From: Jenny Evans. [REDACTED]
Sent: 25 October 2018 10:20
To: Planning
Subject: 53 Mill Road Avenue Extension

RE: 53 Mill Road Avenue Extension

A\130/18/NMA
A\159/18/HH
A\128/18/CLE
A\132/18/HH

PROPOSED ELEVATIONS 1:100

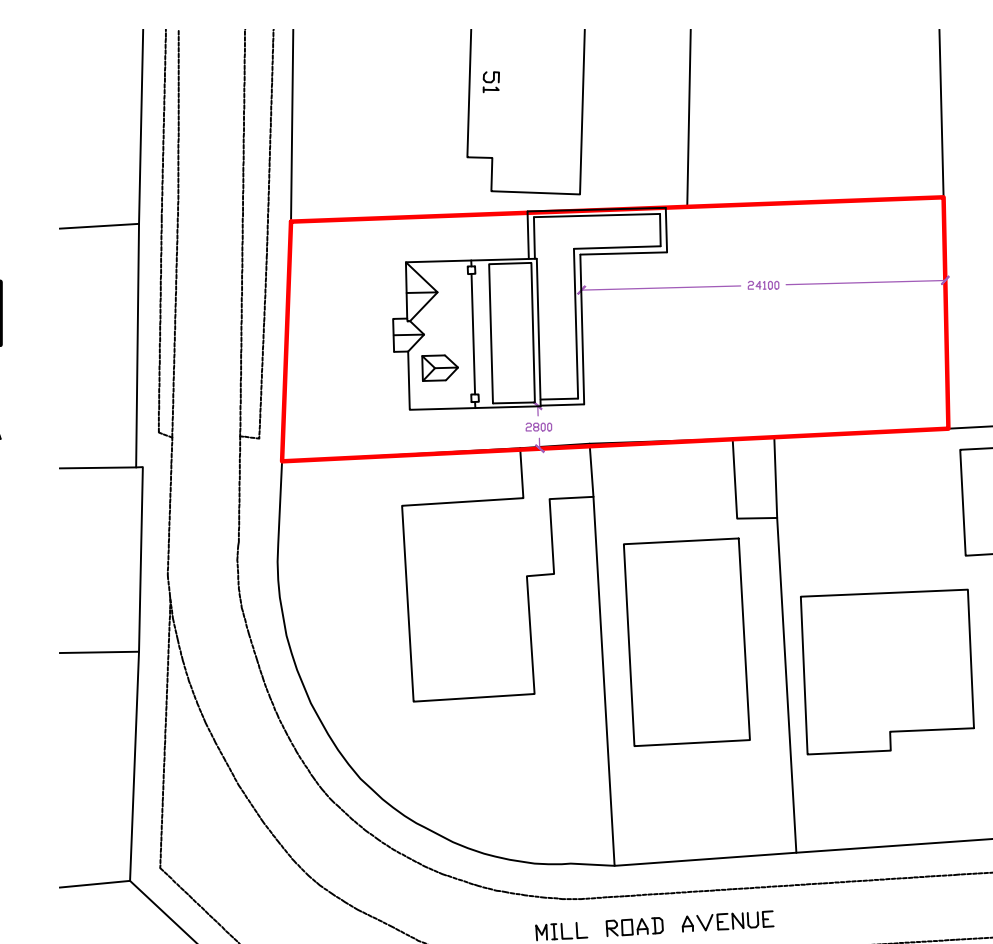
The issues around this extension has always been principally concerned with the finished aspect of the large, rear first floor elevation of the property.

The proposed cladding and vast areas of glass bear no relationship to adjacent properties.

On a personal note, the large rectangular extension dominates my back garden. Privacy issues become daunting, as there appear to be windows and glass doors overlooking numbers 57 and 59 of Mill Road Avenue.
